Rezoning Transportation Analysis
Petition Number: Insert Zoning Petition #2020-190
General Location Identifier: Tax ID 12522705

Revision Log:	Date	Description
	01-21-21	First Review (WB)

Transportation Summary

TECHNICAL DATA SHEET

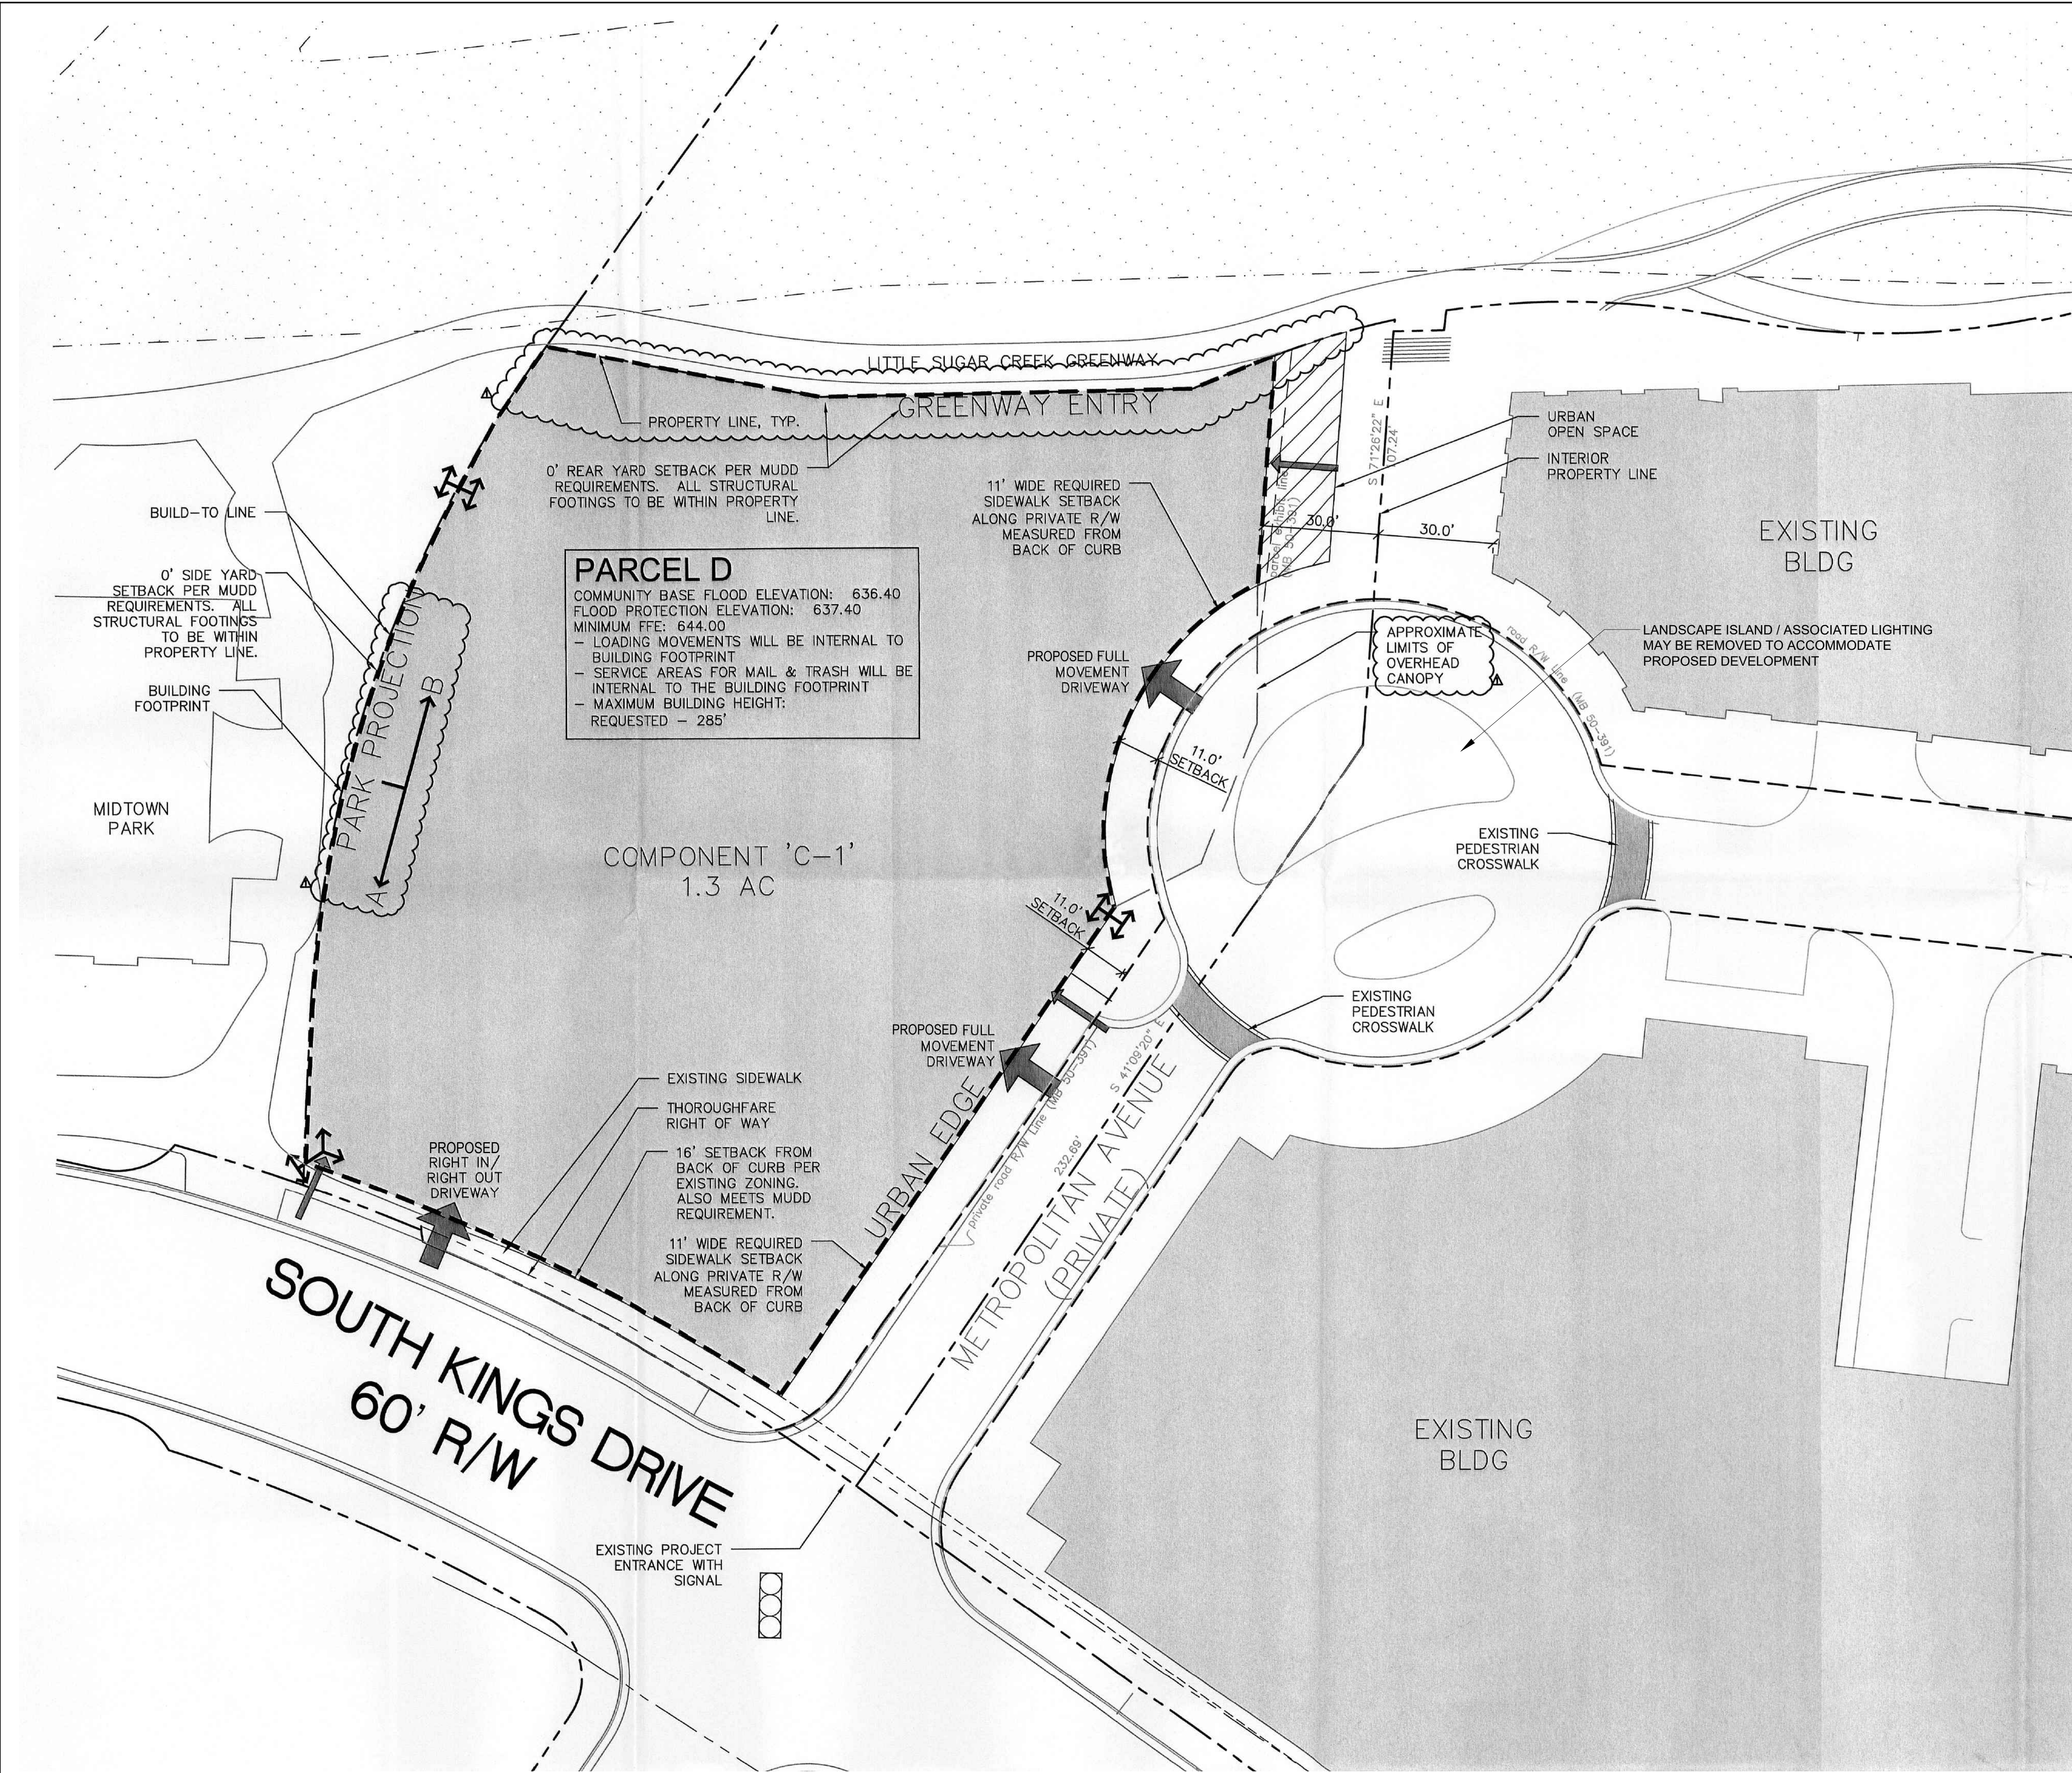
1. **Curbline:** The proposed zoning district has a setback measured from back of the existing or proposed future curbline.
 - a. **Kings Drive:** The future location of curb and gutter is in its existing location.

Label and dimension the curb and gutter from the centerline for each road on the site plan.

3. Revise site plan and conditional note(s) to commit to dedicate 40' right-of-way from the South Kings Drive centerline. The site plan shall label and dimension the right-of-way from the road centerline.

5. Revise site plan to remove proposed driveways shown within the 200' minimum required offset from a signalized intersection in accordance with the City of Charlotte Driveway Regulations (Chapter 4, page 19).
